Our Ref: EN010088

Date: 5 February 2020

**Application by EDF Energy (Thermal Generation) Limited for an Order  
Granting Development Consent for the West Burton C power station**

**Request for further information from the Applicant and the Canal and River  
Trust**

Figure 2. HGV Designated Route Plan (Proposed Development Construction)

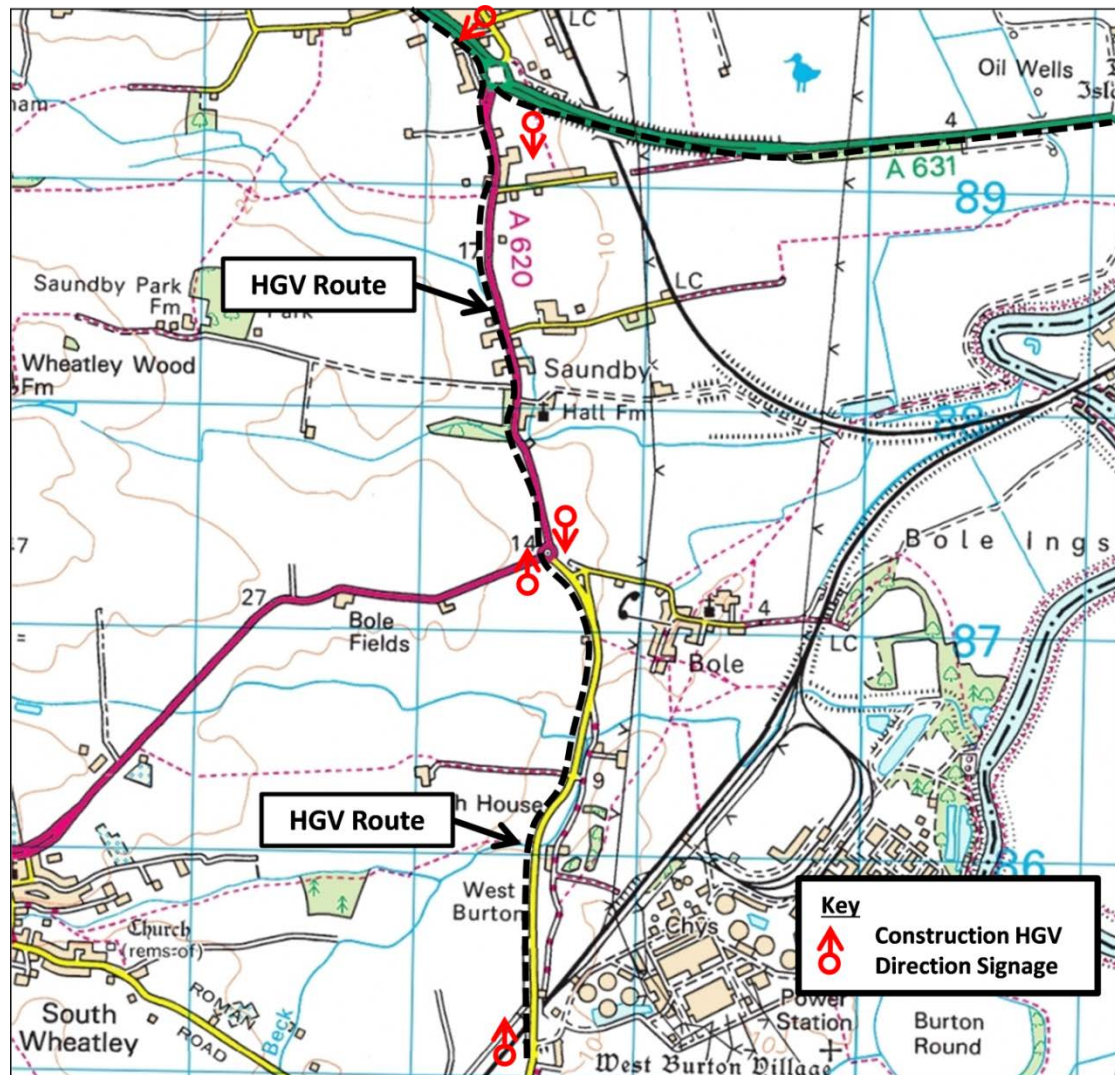
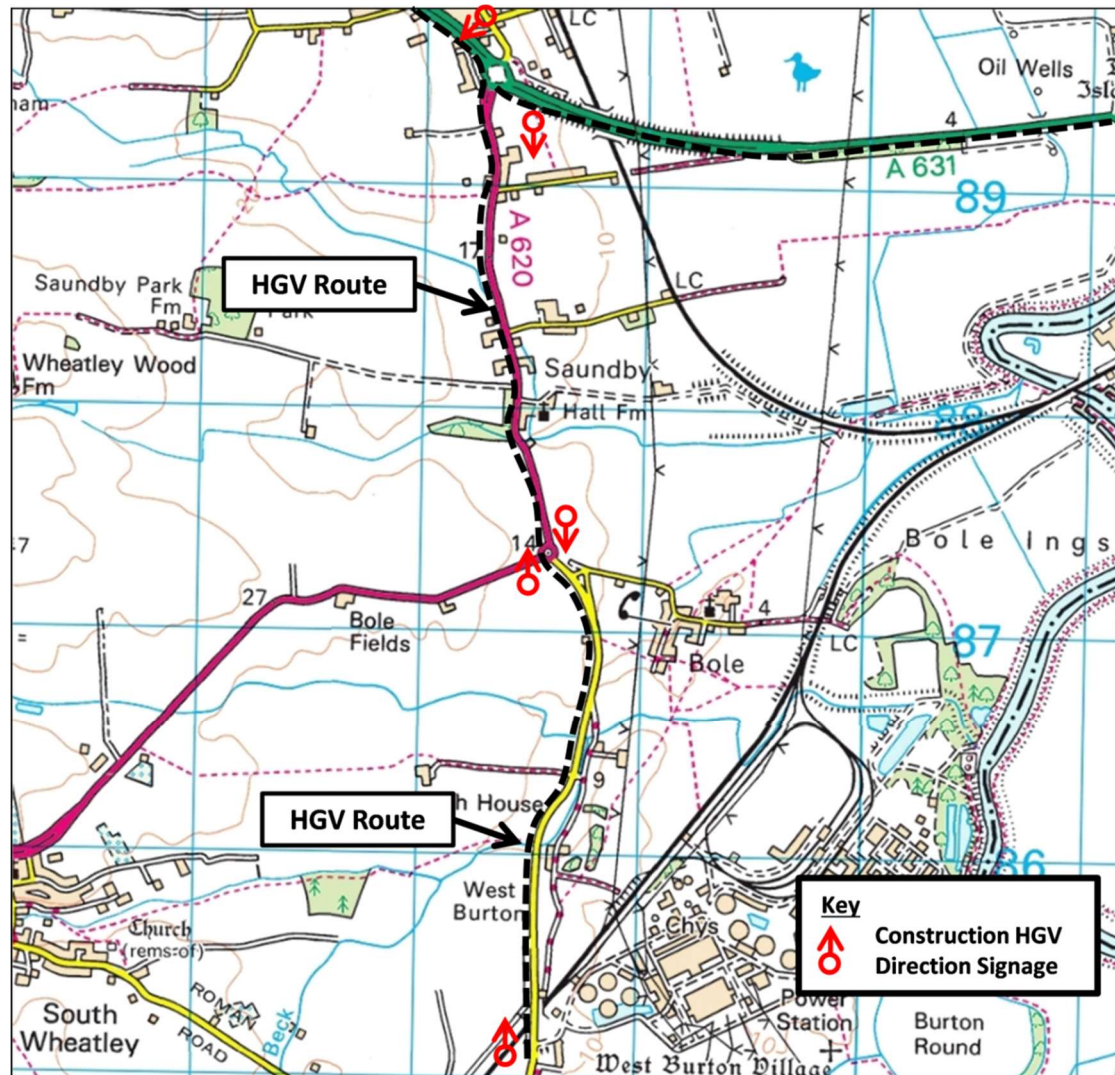
3. For **the Applicant** to confirm that River Road alongside the River Trent to the east of the application site will not be used by any construction traffic/HGVs; and

Figure 3. Abnormal Indivisible Load Route for Proposed Development

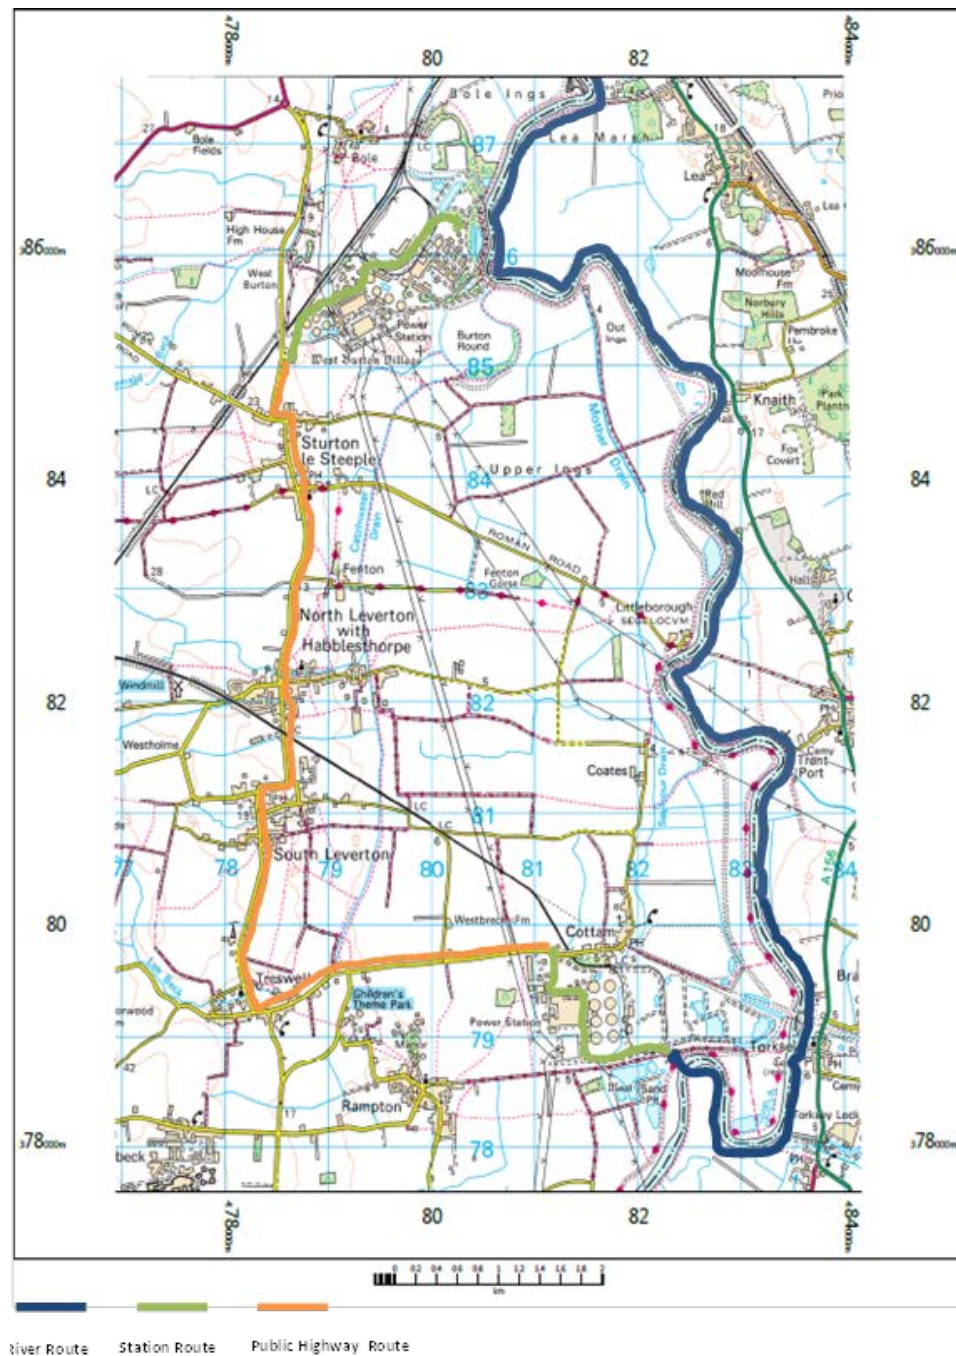
The ExA notes that the Traffic and Transport assessment provides, as stated by the Applicant, the worst-case scenario. However, he also notes that paragraph 5.13.10 of National Policy Statement EN-1 sets out that water-borne (or rail transport) is preferred over road transport at all stages of the project, where cost-effective. Noting this and the submissions which refer to Highways England's publication 'Water preferred policy- Guidelines for the movement of abnormal indivisible loads' including by CRT [REP2-022] and the Commercial Boat Operators Association [REP4-018], can **the Applicant**:

1. Provide its view on the importance/status of this publication; and
2. Provide its view as to whether there is scope to strengthen its commitment to the use of water transport for AILs, where possible, within the framework Construction Traffic Management Plan, and if so, amend it accordingly.
